# Rezoning Transportation Analysis

Petition Number: #2022-107

**From:** Jake Carpenter, PE

Date	Description
11-28-22	First Review (IW)
12-22-22	Second Review (DR)
01-26-23	Third Review (IW)

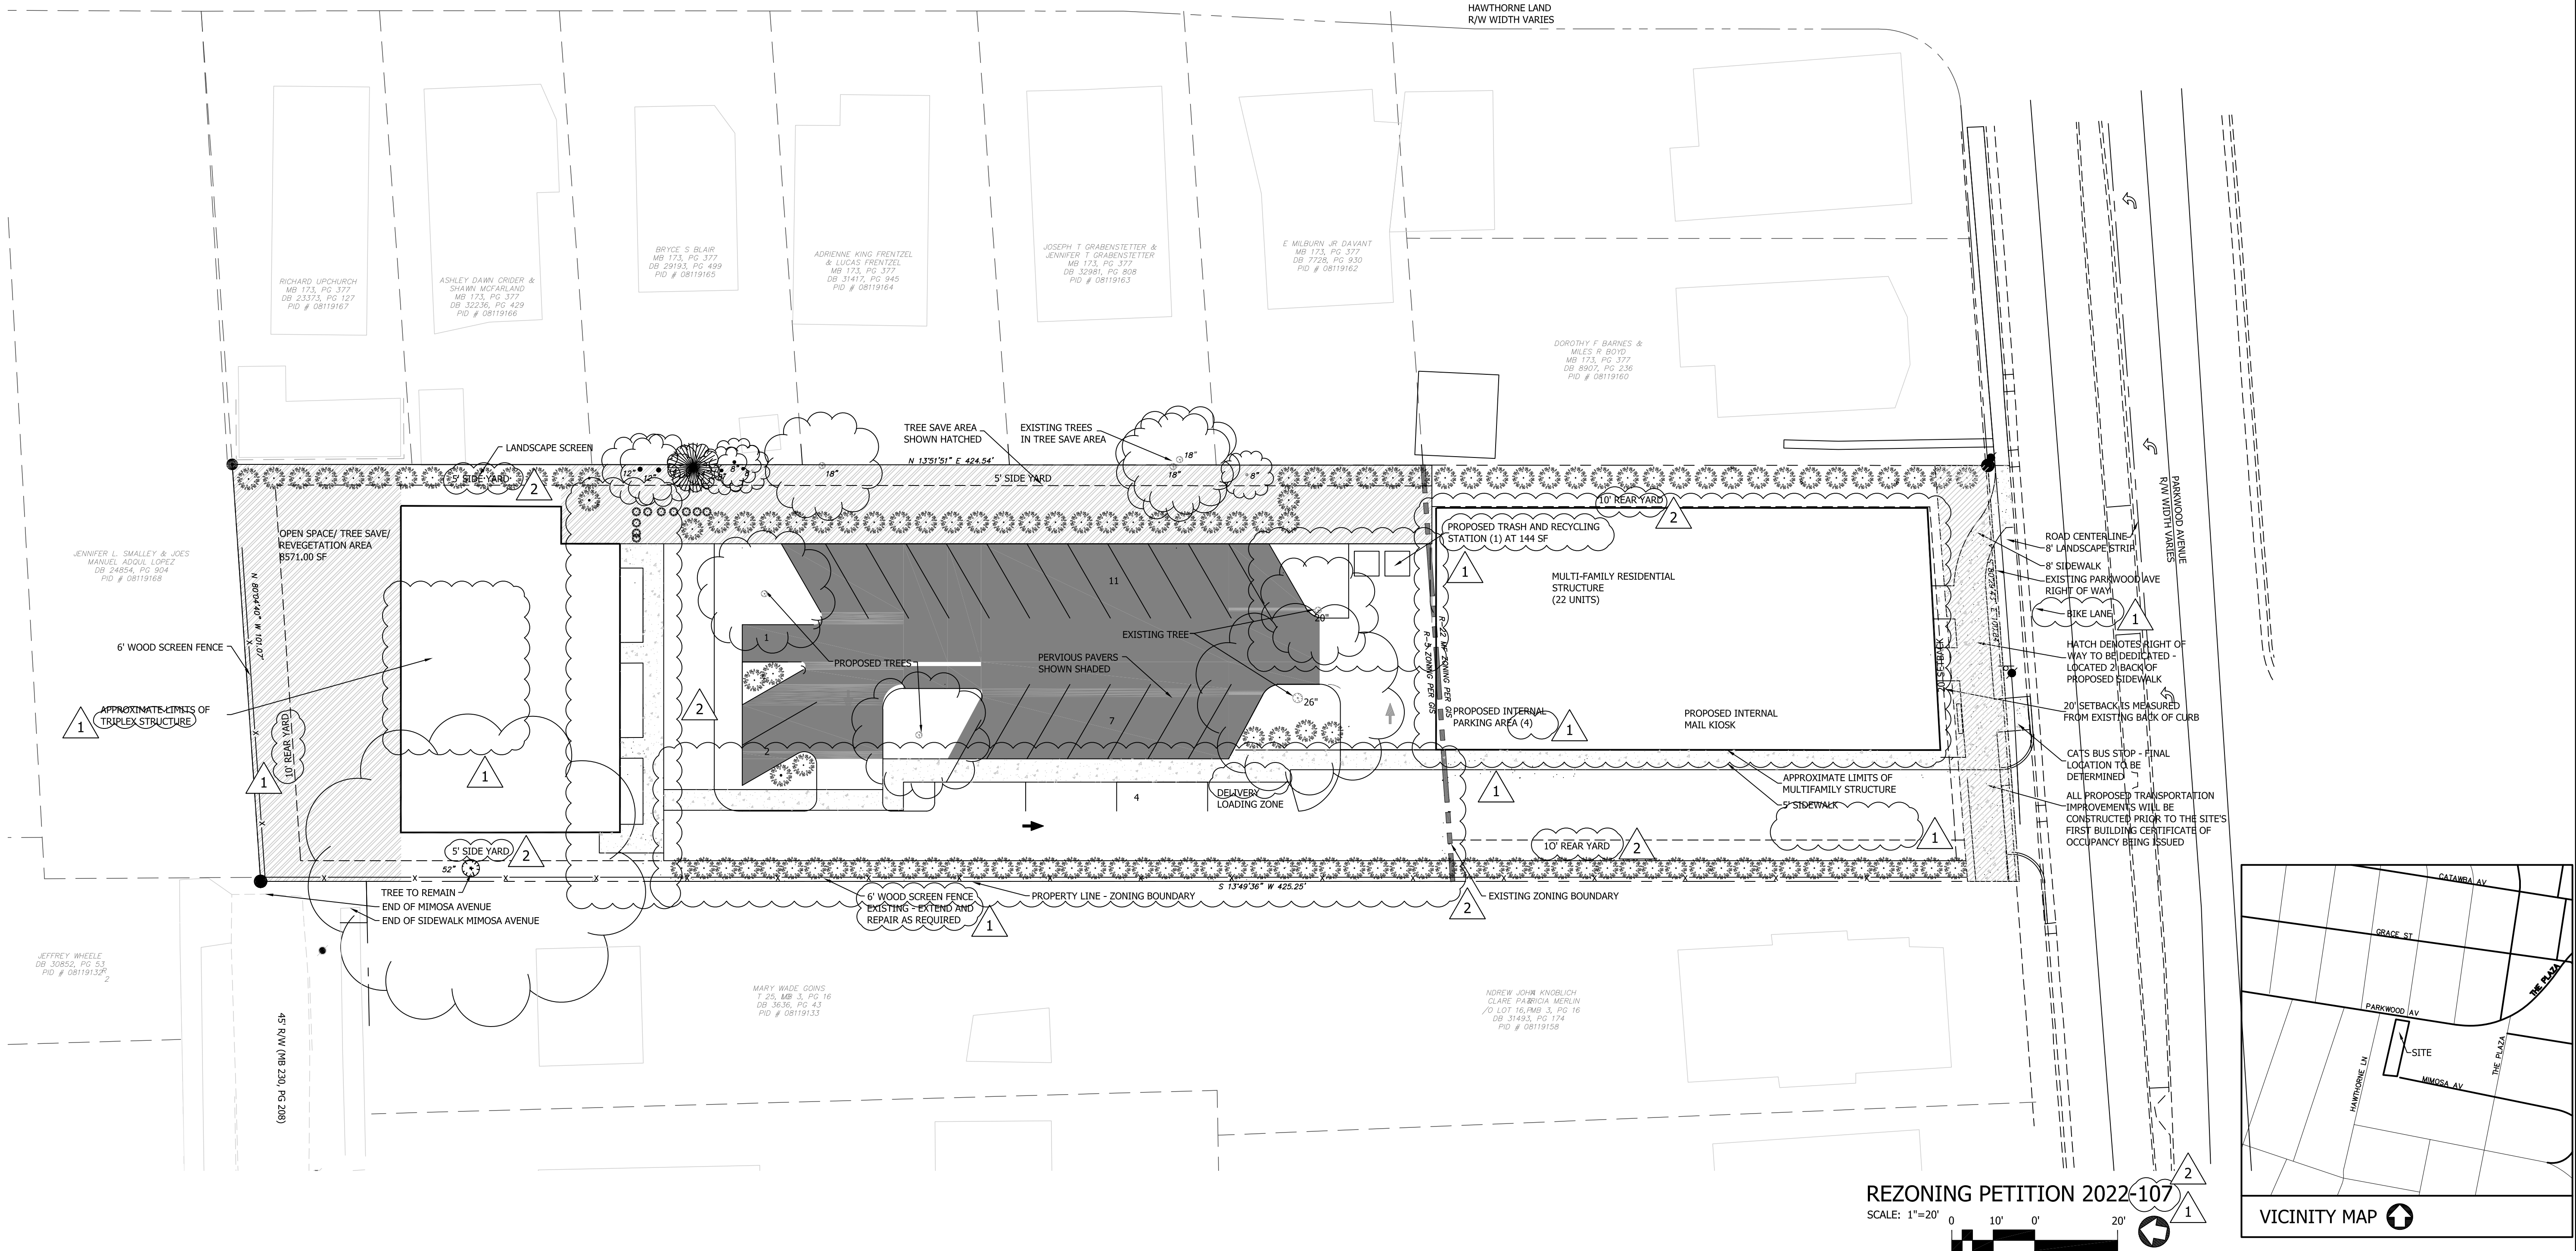
1. **Curblines:** The proposed zoning district has a setback measured from back of the existing or proposed future curblines.
  - a. **Parkwood Avenue:** Location of future back of curb and gutter is 38 feet from centerline.

**Clarified Outstanding Comment from 11-28-22** Label and dimension the future curb and gutter from the centerline for each road on the site plan. Streetscape elements should be constructed at the back of future curb and gutter.

3. **Outstanding Comment from 11-28-22** Revise site plan and conditional note(s) to commit to dedicate 56 feet of right-of-way from the road centerline. The site plan shall label and dimension the right-of-way from the road centerline.
4. **New Comment from 01-26-23** Remove “and pedestrian” from conditional note 2 under Transportation, CDOT requests pedestrian access between Mimosa Avenue and the proposed site.
5. CDOT requests the site plan and conditional note(s) revisions to commit to connect sidewalk near single family structure to existing sidewalk on Mimosa Avenue.

**Clarifying comment from 12/22/2022:** Commit to connect sidewalk near single family structure to existing sidewalk on Mimosa Avenue as shown above.

6. Site plan and conditional note(s) revisions are needed to commit to extending the 8' sidewalk to property line along Parkwood Avenue.

**Clarifying comment from 12/22/2022:** Extend 8-foot sidewalk as shown above to property line along Parkwood Avenue.
